Response to Submissions

For Development at Rathmorrissy, Pollnagroagh,
Moanbaun, Castlelambert, Knocknacreeva,
Caraunduff, Caherbriskaun, Lisheenkyle East,
Barrettspark, Cashla, Athenry, County Galway.

on behalf of Bord Gáis Energy Limited

Client	Bord Gáis Energy Limited	
Project Title	Cashla 220kV Substation and Grid Connection	
Document Title	Response to Submissions	
Document Comprises	Volumes	0
	Pages (Including Cover)	69
	Appendices	2
Prepared by	Muireann Carroll	
Checked by	PG	
Office of Issue	Dublin	
Document Information	Revision	0
	Status	Final
	Issue Date	August 2026

300101269-DR-137

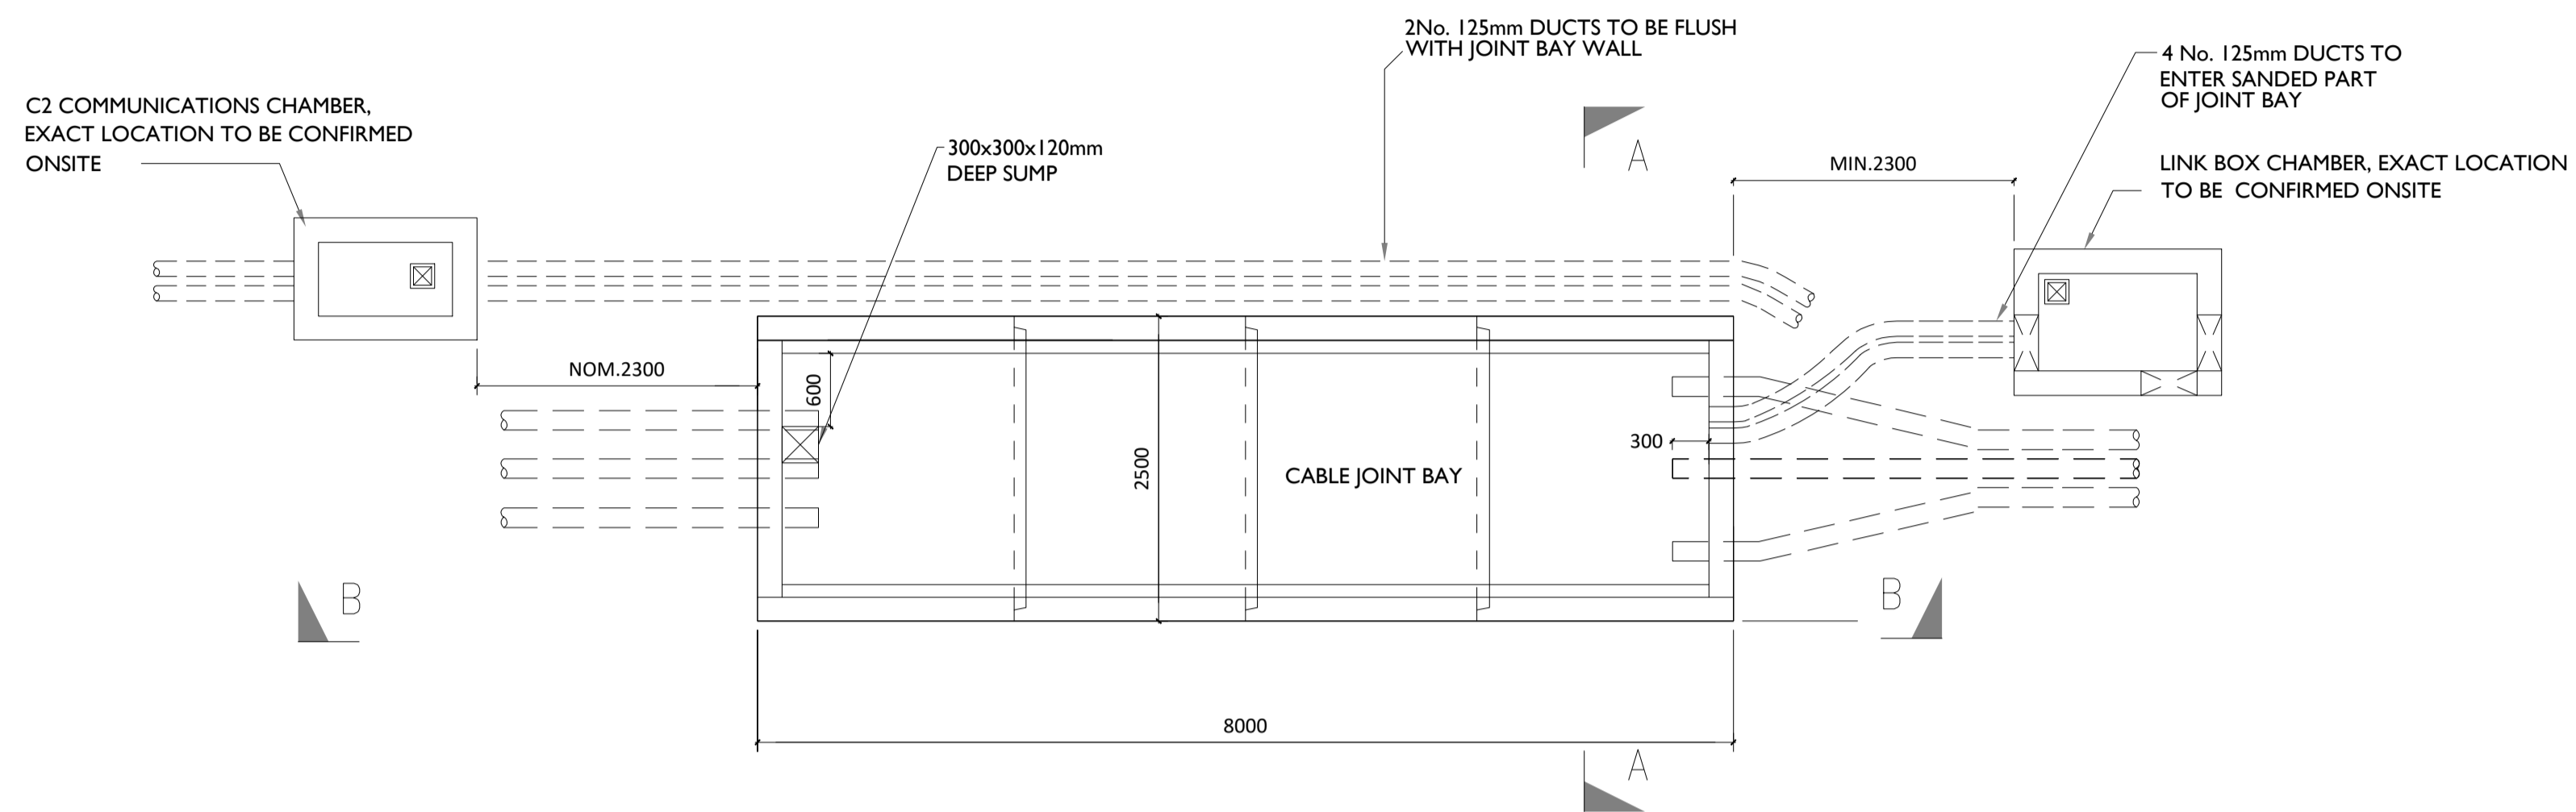
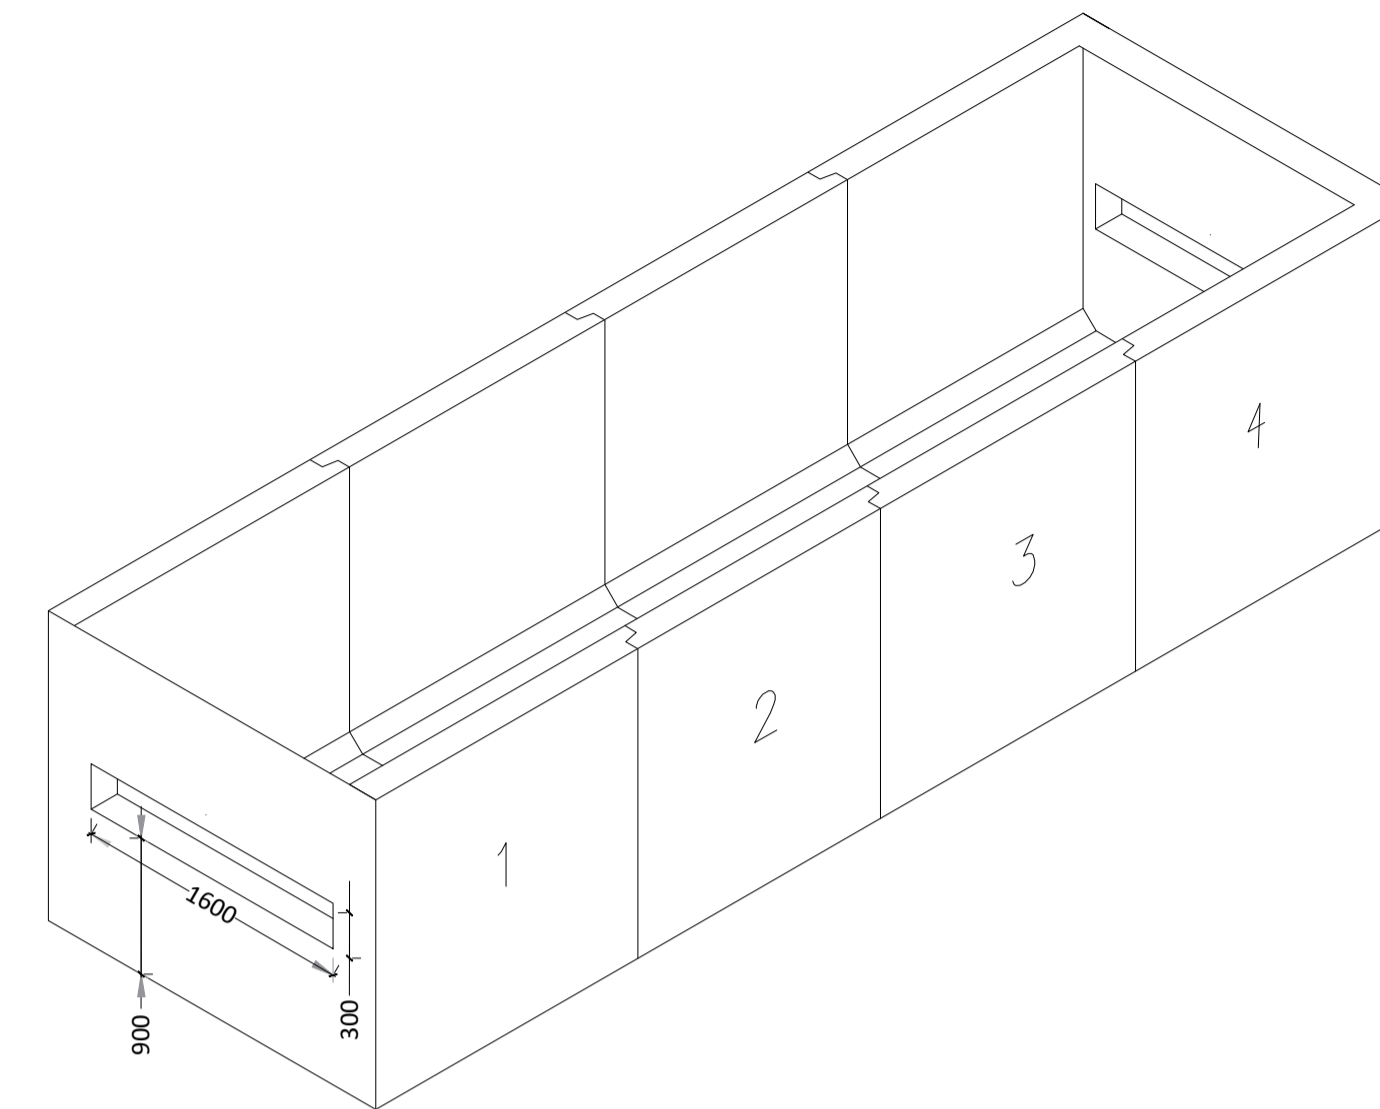
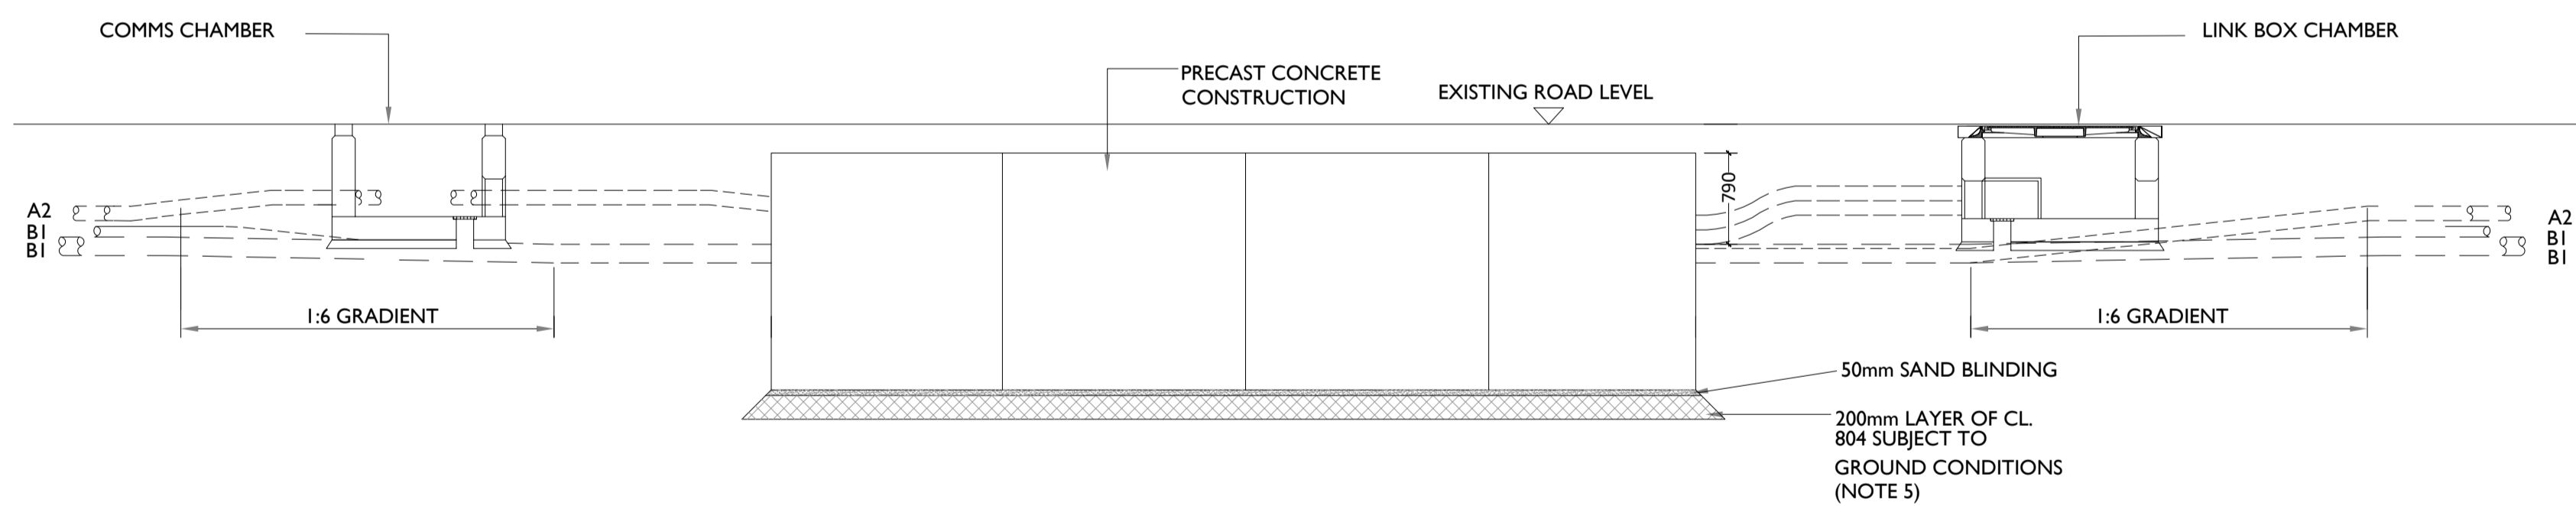
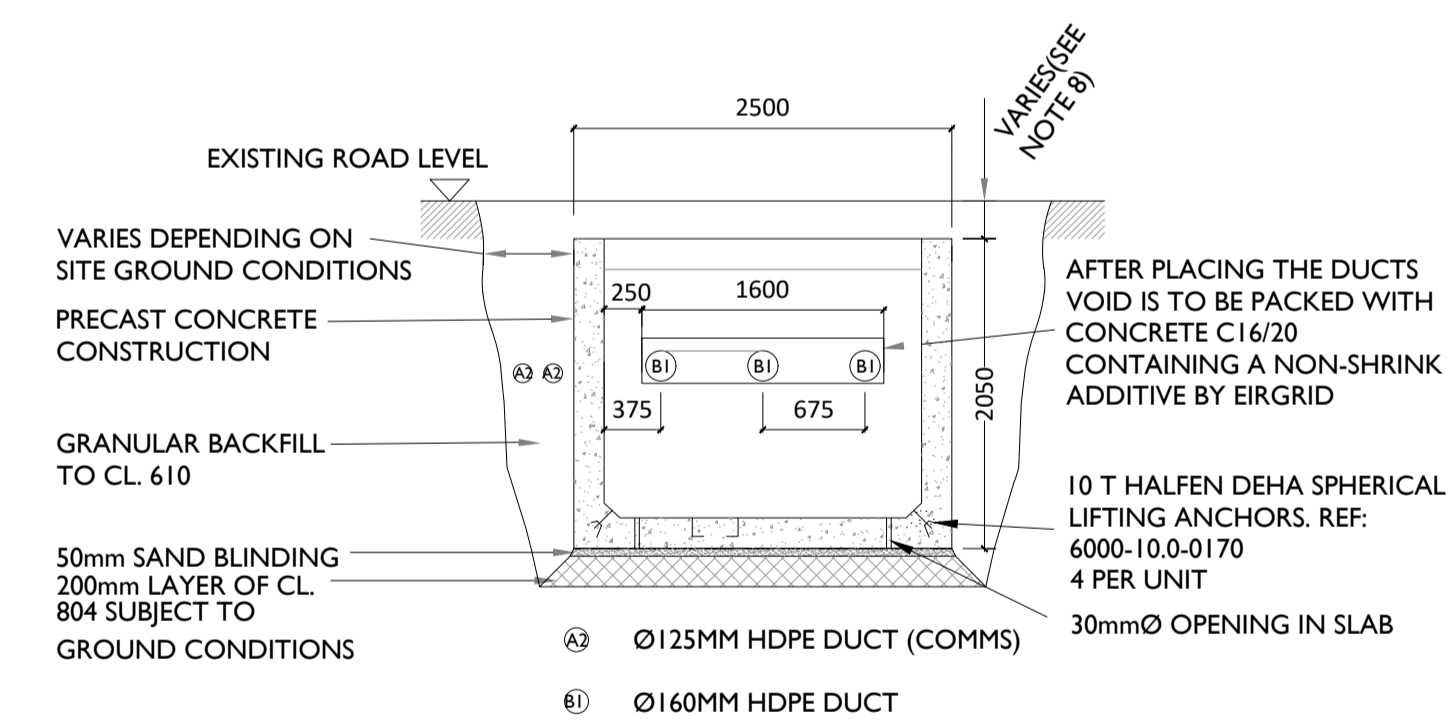
Galway County Council raised a concern regarding the proposed location of 10 no. joint bays and associated communications infrastructure within the public road carriageway. It considered that the scale and depth of the proposed structures would effectively sterilise the roadway and interfere with the Council's ability to undertake future drainage, watermain and service connection works. It therefore requested that the joint slabs be relocated off the public road and positioned within adjacent lands under the applicant's control as it had not been demonstrated that no practical off-carriageway alternative exists. The Roads Department also required that any joint bay structures be subject to a Technical Acceptance Report in accordance with the relevant standards and circulars, including certification from the relevant design, assessment and checking parties. Clarification was also requested regarding the type of lids proposed, compliance with TII standards, backfill

and compaction standards, and ongoing maintenance responsibility for link box and chamber lids.

The placement of Joint Bays (10 in total) for this project has been strategically sited within natural widenings, hard shoulder areas, or access/ entrances into arable lands where available. 5 Joint Bays out of 10 in total are sited off the road curtilage as follows:

- *Joint Bay 01 within the Cashla Substation bell mouth*
- *Joint Bay 03 Discarded section of local road @ Ch1480m*
- *Joint Bay 05 with widened section of roadway @Ch.3190m*
- *Joint Bay 08, discarded section of local road @Ch.5850m*
- *Joint Bay 10 OCGT access road*

The remaining joint bays are located within the road curtilage (refer to the Construction Grid Connection Report enclosed in Appendix 2-7, Volume 3 of the EIAR). Galway County Council have raised concerns relating to the scale and depth of the proposed structures and the impact this could have on sterilising the roadway and interfering with the Council's ability to undertake future drainage, watermain and service connection works are noted. As set out in the planning application drawings the current proposal provides for a minimum depth of cover above Joint Bays of 300mm in paved roads (refer to Drawing Ref. 300101269-DR-136-P2, Note 8B). The 5 no joint bays which are proposed within the road carriageway will be installed with a cover depth of 600 mm, ensuring sufficient clearance to accommodate future maintenance and drainage works while protecting the underlying cable infrastructure.

In accordance with the Department of Transport's 'Interim Guidance to Road Authorities regarding the proposed placement of Medium or High Voltage

electricity assets, including ducts, cables, and associated infrastructure under public roads' (March 2026), the Joint Bay structures within the road will conform to standards required by the Roads Authorities and will have a concrete lid, unless exceptional circumstances arise and are otherwise agreed with the Roads Authority. The detailed design of the joint bay structures, Communication chambers, Earth Link boxes will be agreed with the roads authority via Technical Acceptance of joint box/bay and ancillary chamber structures beneath regional and/or local roads, carried out in accordance with DOT Circular RW 10/2021. All works shall be designed and carried out in accordance with the relevant Transport Infrastructure Ireland (TII) standards, specifications and requirements, including those relating to road openings, reinstatement, materials, workmanship, inspection and certification. Backfilling and compaction shall be completed using approved materials and methods to achieve the required bearing capacity, settlement control and surface reinstatement standard, with records retained where required to demonstrate compliance. The installation, reinstatement and final finish around all link boxes, chambers and associated covers shall be completed to a safe and durable standard, ensuring that lids are correctly seated, level with the surrounding surface, traffic-rated where applicable, and do not present a hazard to road users, pedestrians or maintenance personnel. Responsibility for the ongoing inspection, maintenance, repair and replacement of link box and chamber lids shall remain clearly assigned, including prompt action where defects, rocking covers, settlement, damage or safety concerns are identified.
